Application Ref: H03-0548-26

Proposal: **Erection of 119 dwellings and a village hall along with ancillary development including the construction of an attenuation pond - Approved under H03-0598-24. Modification of Condition 1 to allow amendments to previously approved plans, Condition 4 relating to external materials included within amended plot schedule, Condition 7 relating to updated travel plan & to amend wording of condition, Conditions 9, 10, 11 relating to the removal & replacement of 3 trees at the site entrance as part of the revised landscape scheme & attention basin & Condition 12 relating to play area**

Location: **Home Farm, Littleworth Drove, Deeping St Nicholas, Spalding**

Deferral: LCC is not currently in a position to support the application and requests further assessment, supporting evidence, revisions and/or dialogue, as set out in the response.

PROJECT	Residential Development Land Off of Littleworth Drove Deeping St Nicholas
DATE	June 2026
TITLE	Proposed Site Plan
SCALE	1:500
ORIGINAL SIZE	A1
DRG STATUS	PLANNING
DRAWING NUMBER	LDC4244-102Q

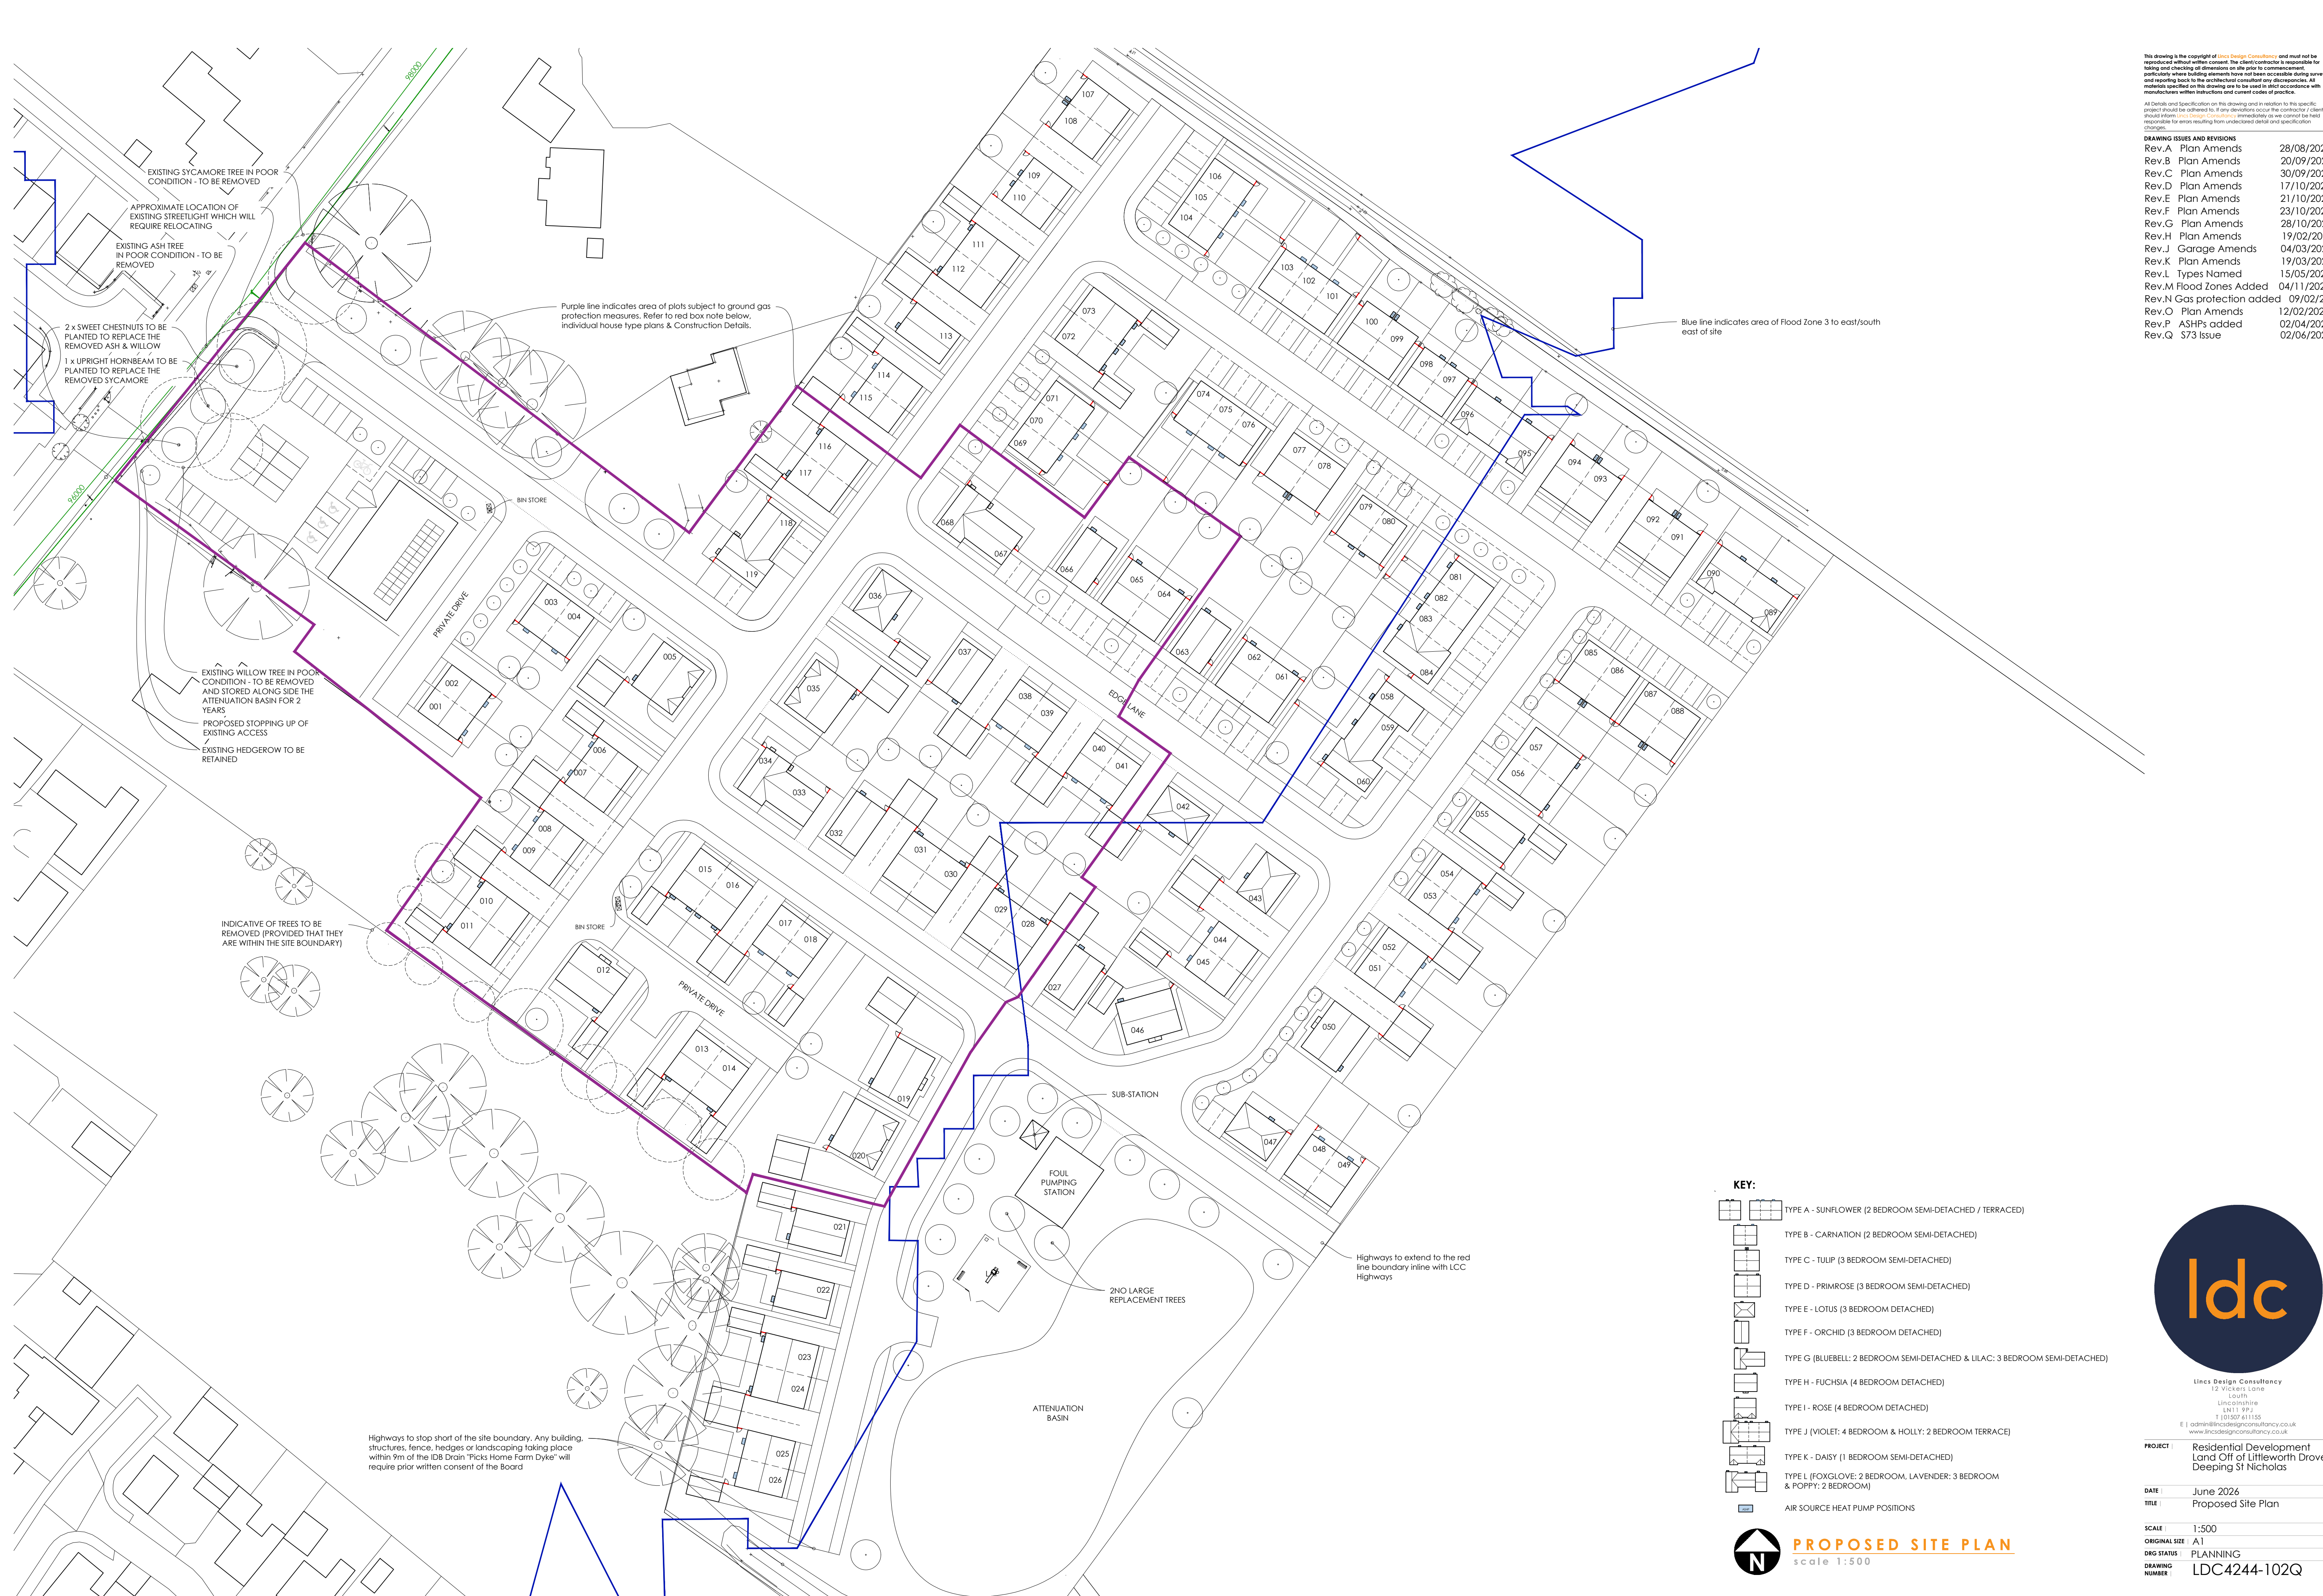
Whilst Sheffield stands are provided at the village hall and the quantum of provision is acceptable, further clarification is required to confirm the inclusion of weather protection and provision for accessible and cargo cycles, in line with LCC guidance.

The proposed enclosure of the play area is noted; however, the current approach appears to fall short in terms of permeability and integration with the surrounding public realm.

Clarification is sought on how the play area will remain accessible in wet conditions, including whether an appropriate surfaced path (e.g. bound/gravel or similar all-weather route) will be provided to ensure inclusive and year-round access, and if a risk assessment means that the fencing is required.
